Description: Erection of 40 dwellings (Outline H09/0963/98)

Location: Land off St Marks Road
Holbeach St Marks

Amendment: Amend design of bungalows and garage - Plots 37 and 38
(Dwg. nos. 01/58/08/B and 14202/01.J)

**TOWN AND COUNTRY PLANNING ACT 1990
NOTICE OF ACCEPTANCE OF AMENDMENT**

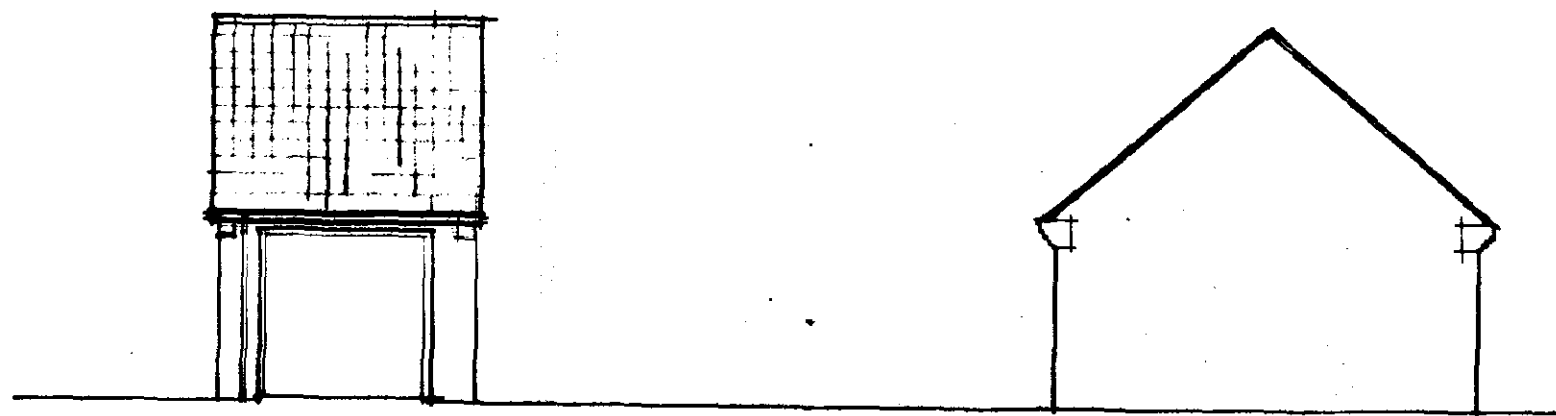
Plots 37 & 38

PROJECTION OF GARAGE TO FRONT ELEVATION
INCLUDED.

ROOF TO GARAGE ROTATED 90° SO GARAGE
DOORS ARE IN GABLE END.

The amended details submitted in respect of the above proposal have now been considered and there are no objections to the amendment being implemented to the extent described above.

Proposed Site Plan

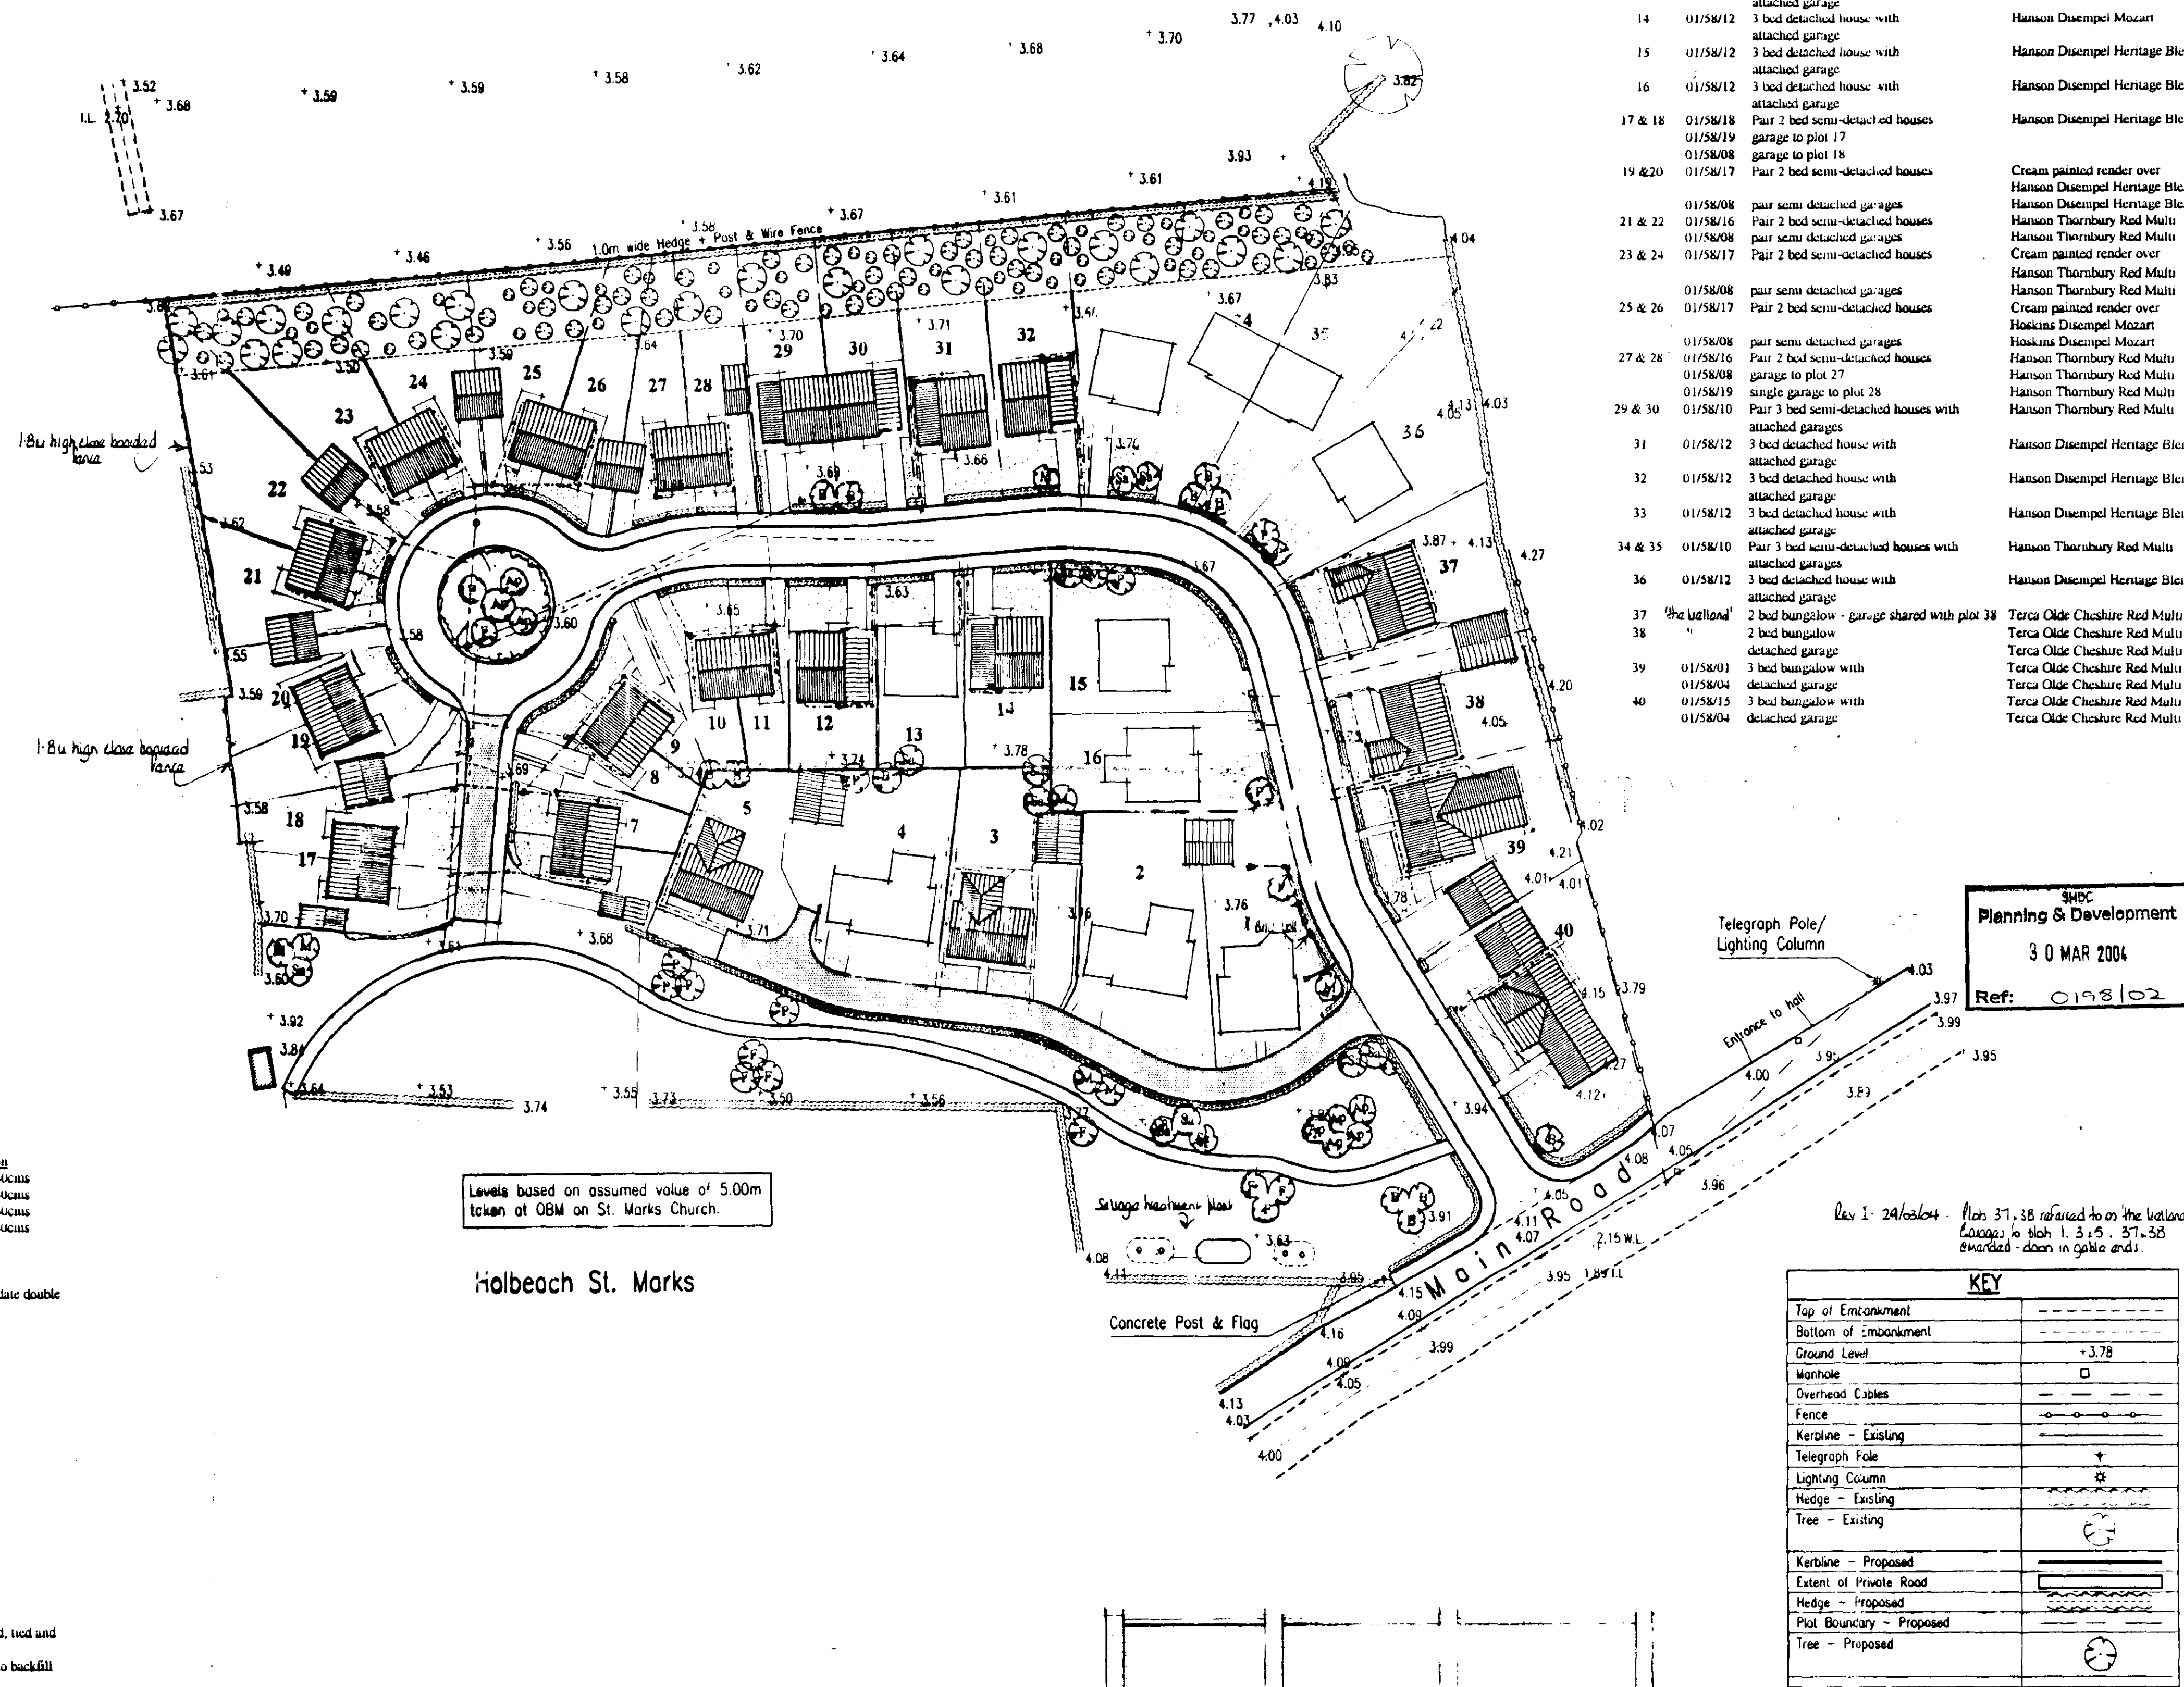
2 COPIES OF THE DRAUGHTS, BY NO. H202/01 REV L.
- 2nd of 2004
